# FALCON ACRES EL PASO COUNTY CONSTRUCTION DRAWINGS JANUARY 2023

PCD FILING NO.: SF223

CONSTRUCTION PLANS  
COVER SHEET

DRIVEWAY CULVERT TABLE

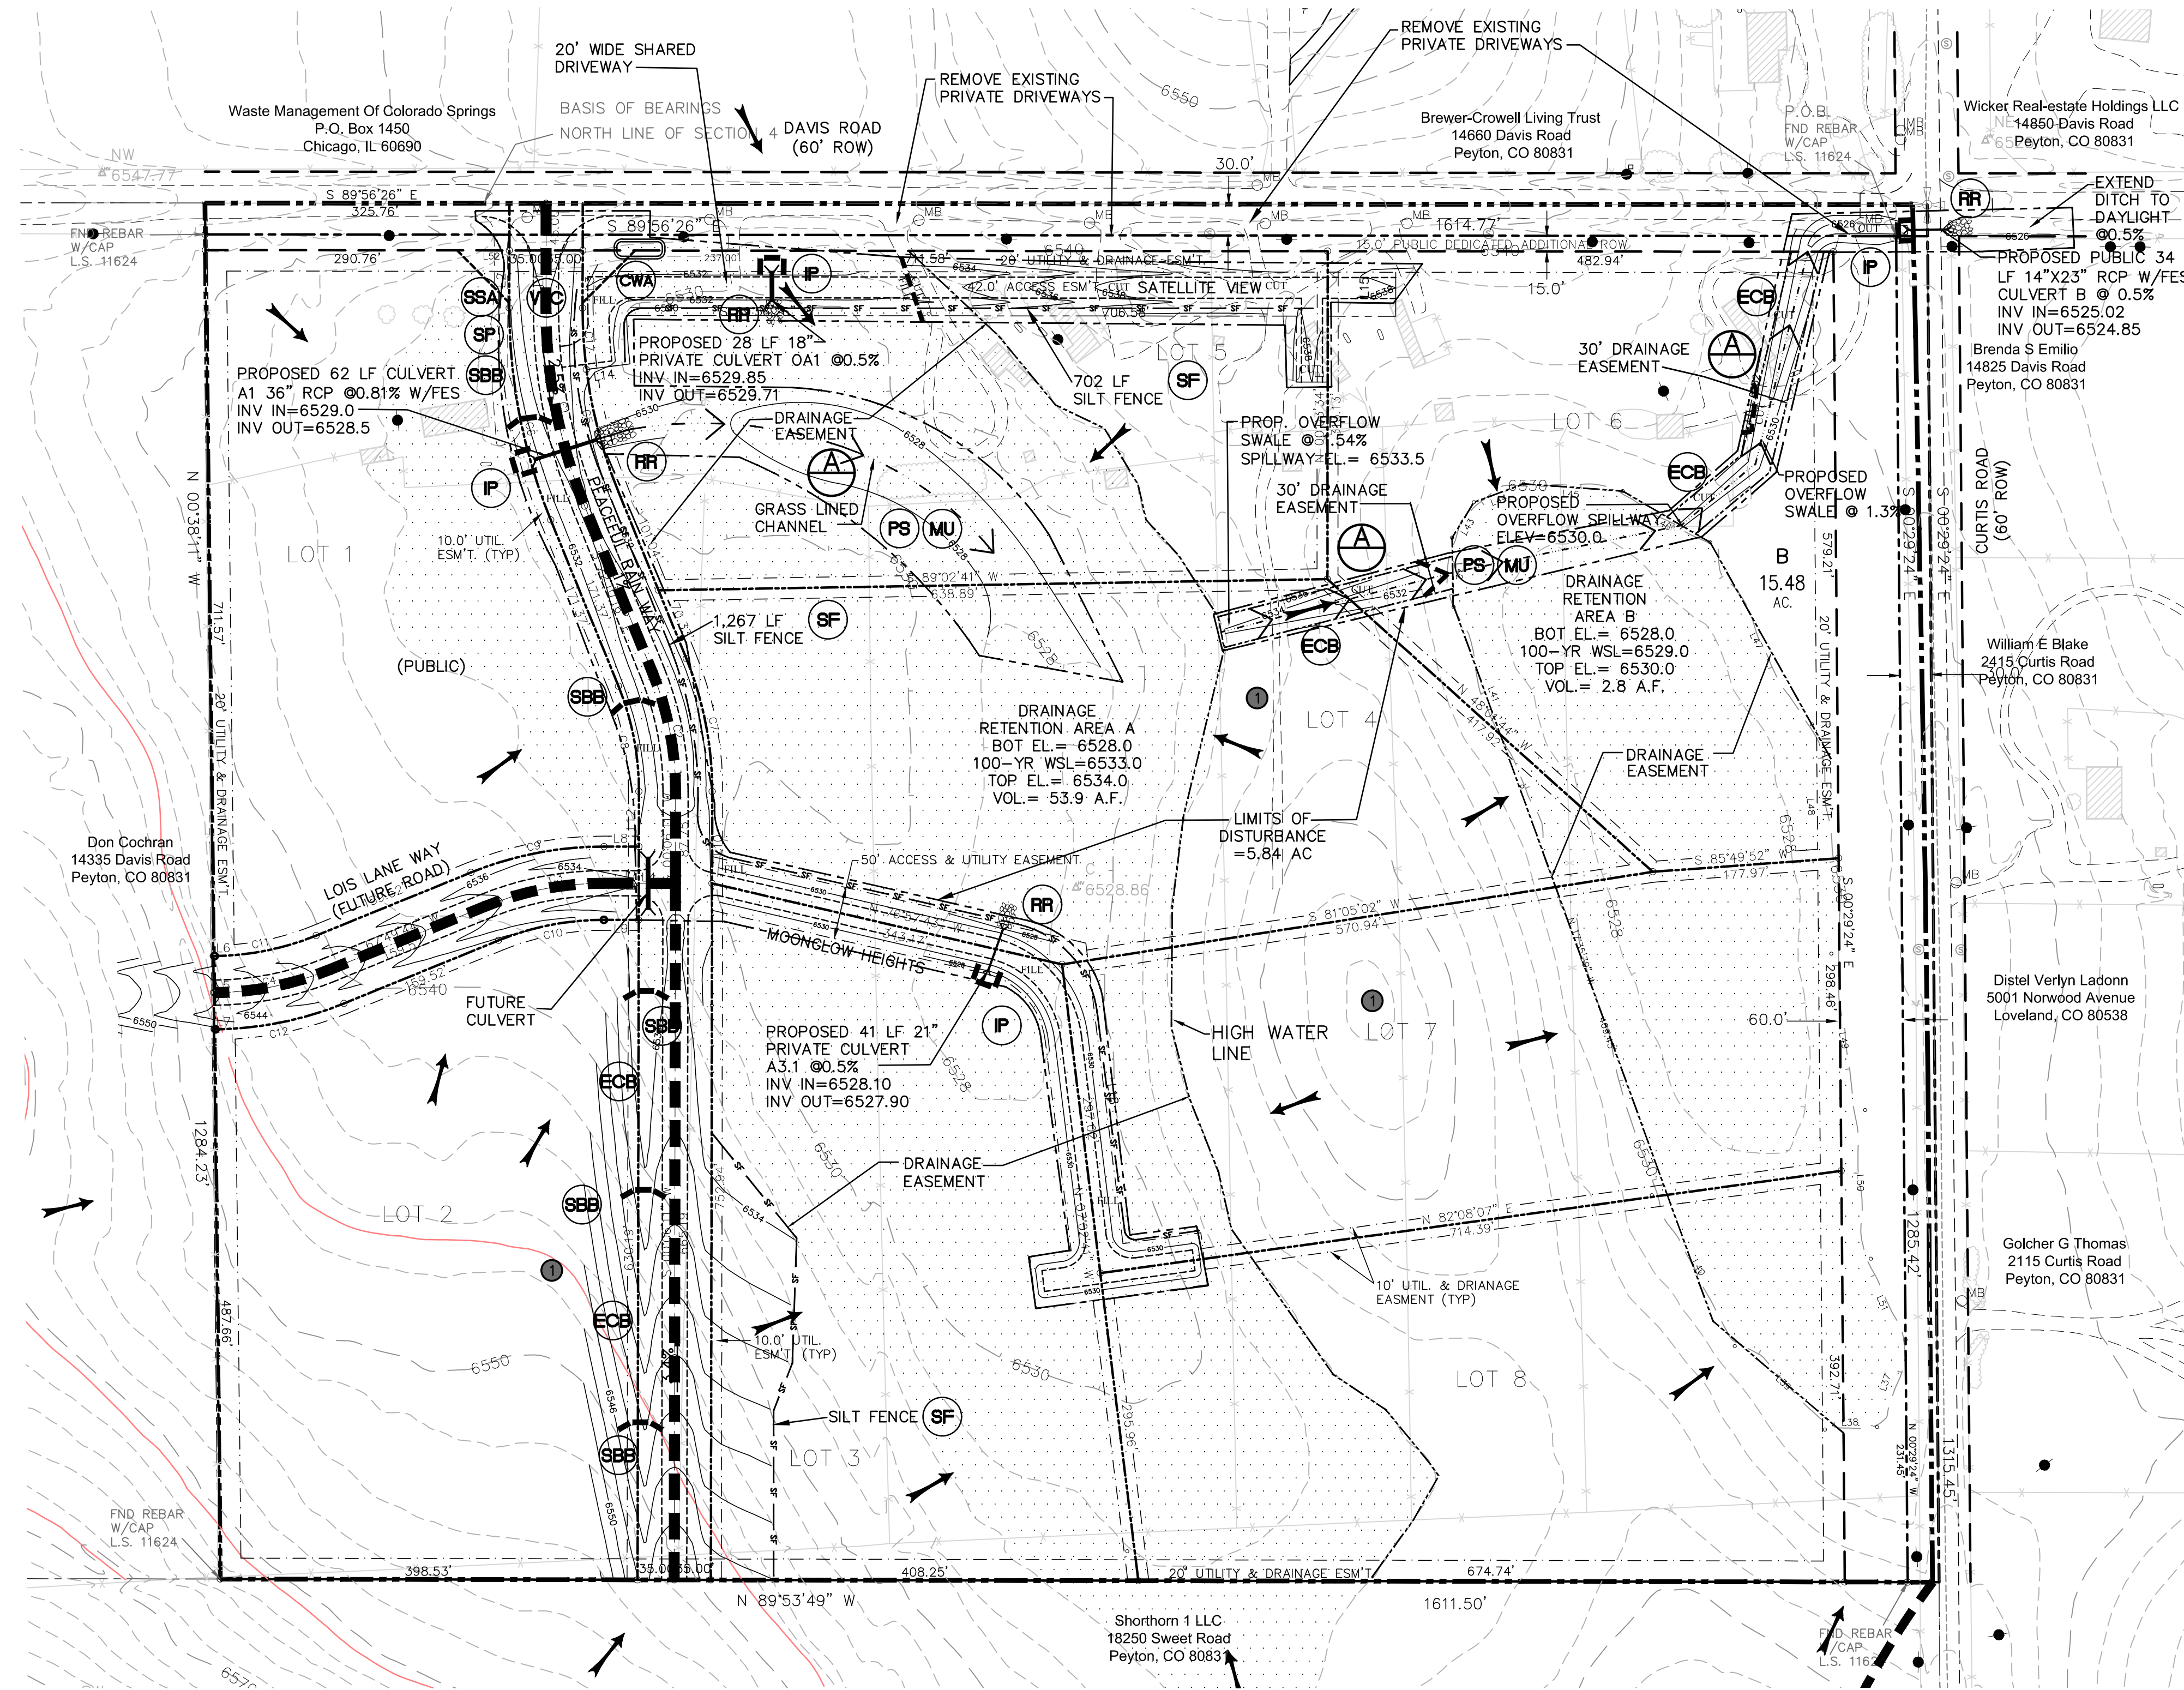
Note that per MHFD criteria, forebays are required for concentrated inflow points with >1ac of tributary impervious surfaces. The area that I have shaded is the approximate tributary area of impervious surfaces, which is about 0.6ac. So a forebay is not required for this retention pond. Please document this in the drainage report.

Since over an acre of soil disturbance is tributary to this point, a sediment basin is required per GEC Checklist Item "x." The sediment basin does not have to be at this exact point, it could be put upstream of here (on the other side of the culvert for example) if preferred.

How will this be accomplished? Will they be fenced off?
